**Re: Noon Day 2500 2nd St NW
Grading and Drainage Plan
Engineer's Stamp Date 10/31/13 (H14/D067)**

Based upon the information provided in your submittal received 10-31-13, the above referenced plan cannot be accepted for Grading Permit and Building Permit until the following comments are addressed.

ENGINEER'S SEAL	NOONDAY	DRAWN BY WCHWJ
	GRADING AND DRAINAGE PLAN	DATE 12-05-13
		21344-LAYOUT-10-10-13
12-05-13	1806 CENTRAL AVENUE SUITE 201 ALBUQUERQUE, NM 87106 (505) 872-0999	SHEET #
DAVID SOULE P.E. #14522		JOB # 21344

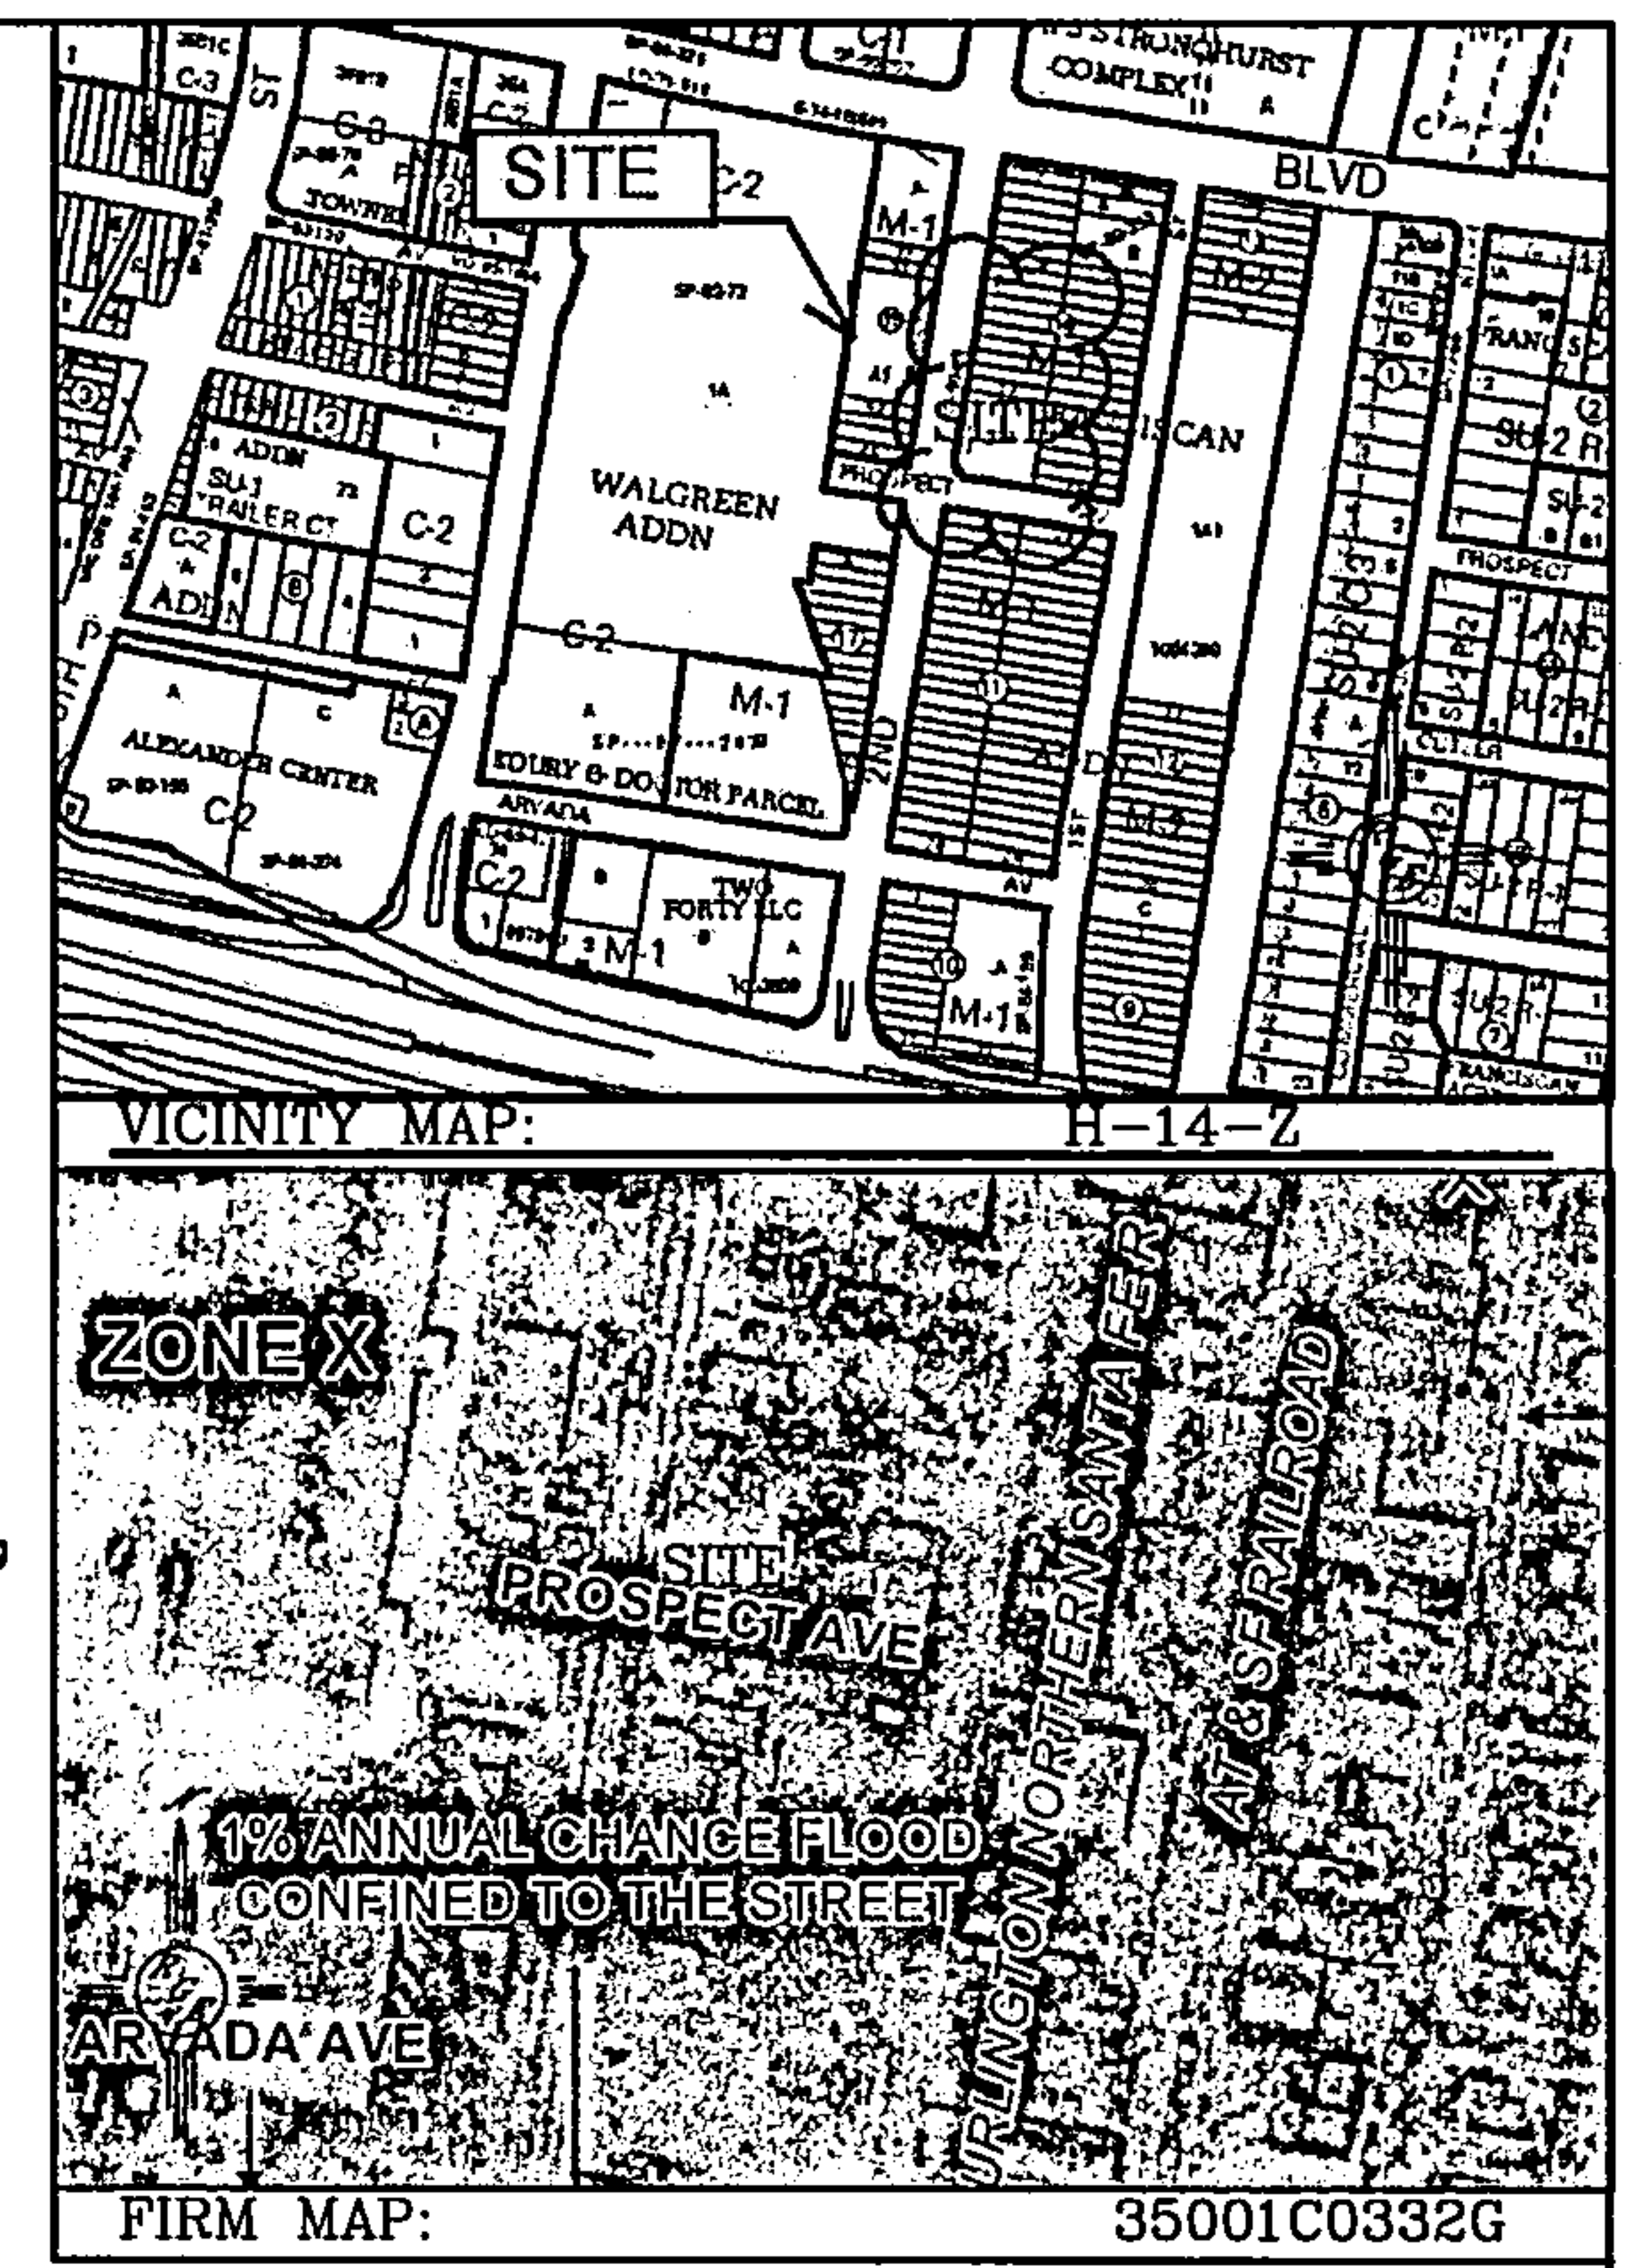
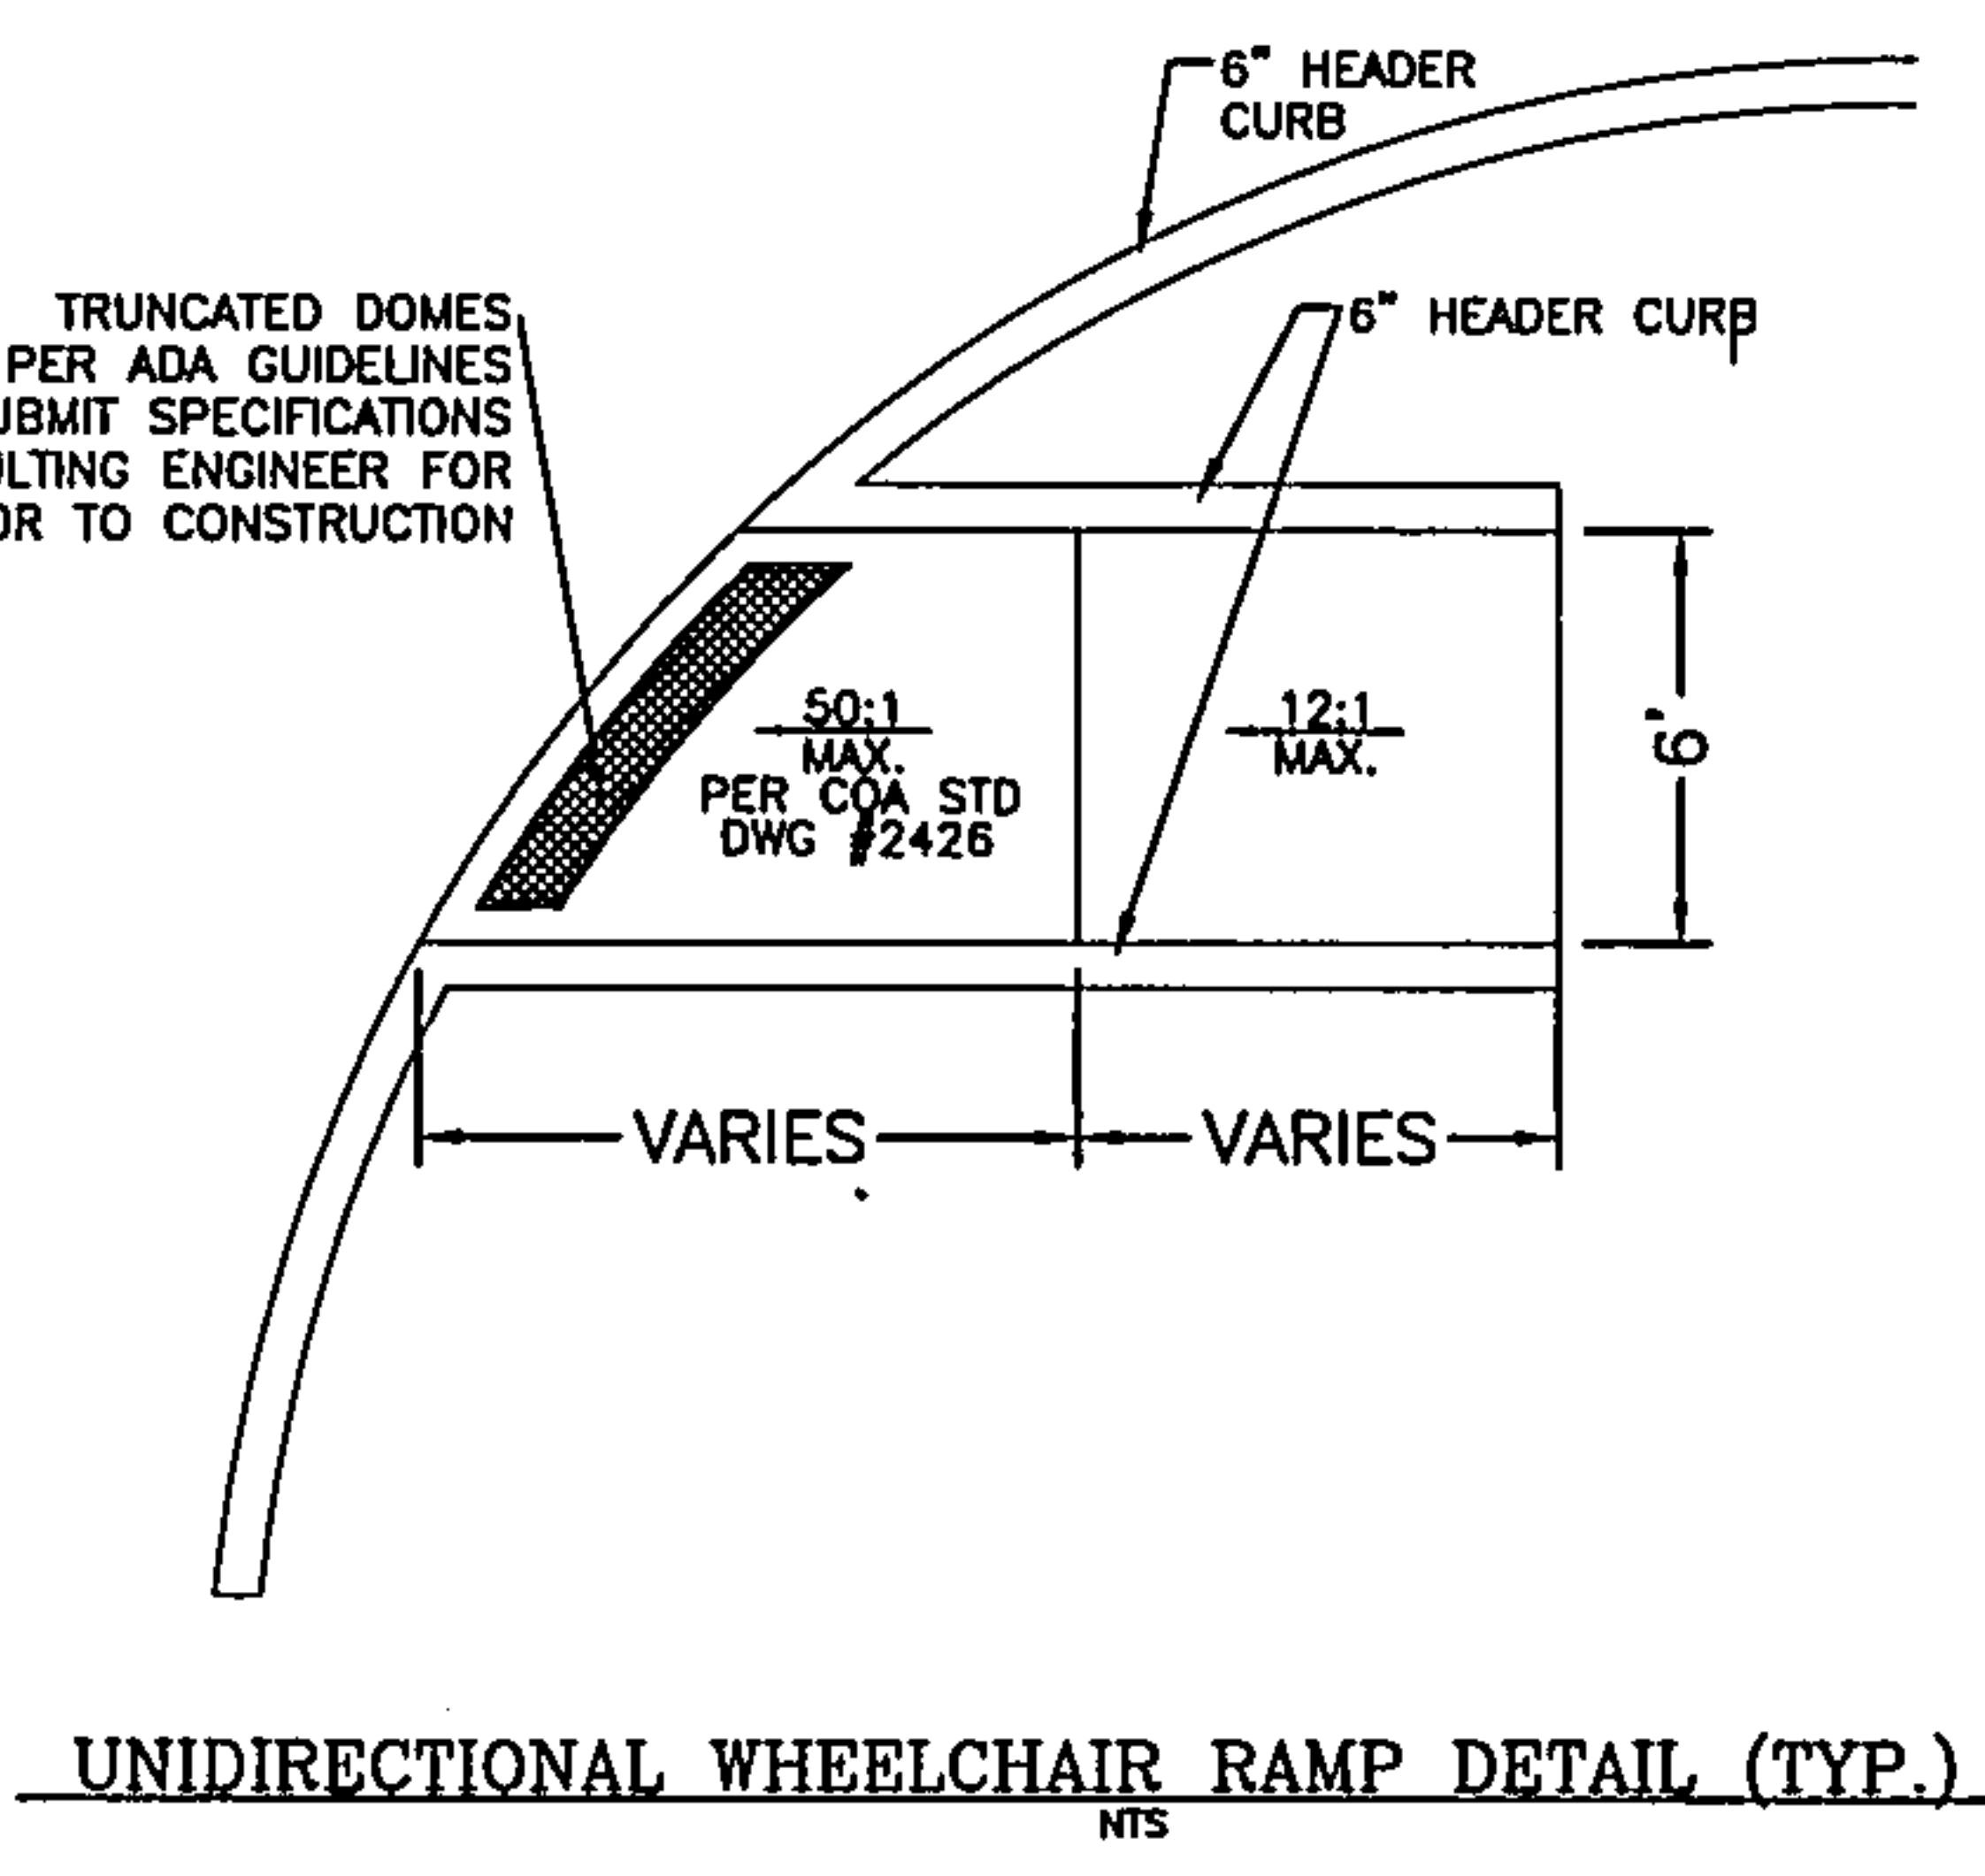
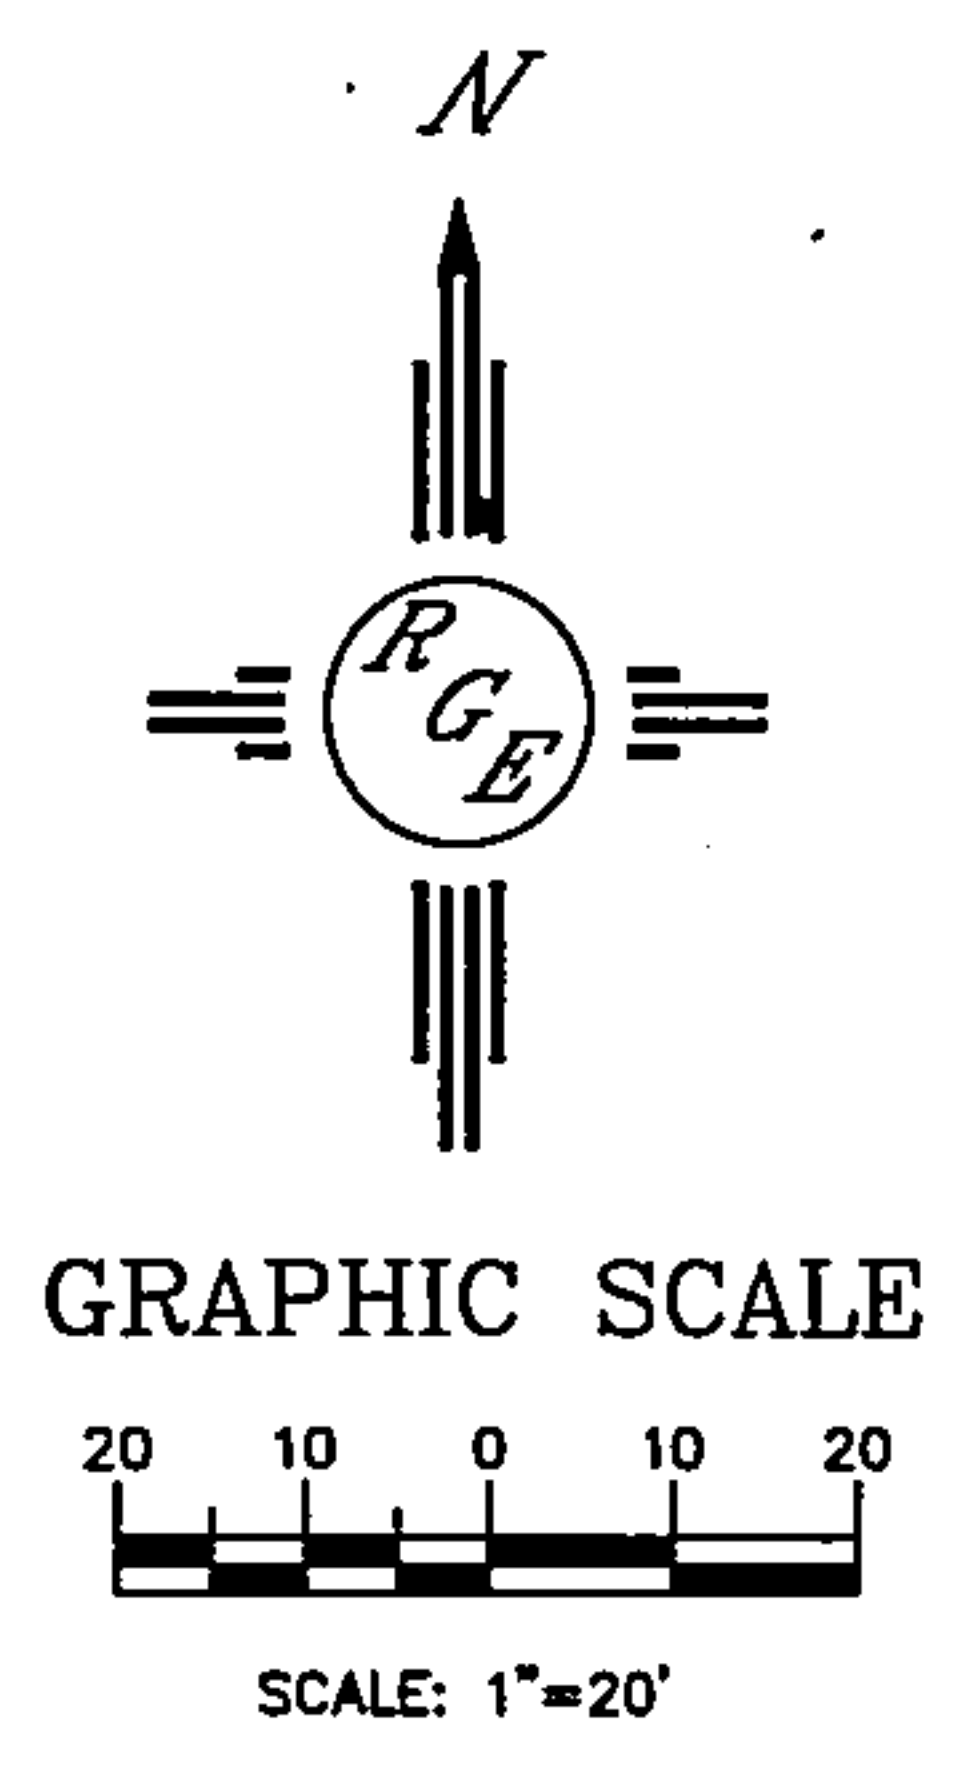
- Extend the sidewalk culvert plates two (2) feet passed the property line.
- Provide calculations.
- Water blocks are needed at the driveways.
- Provide spot elevations along the property lines.
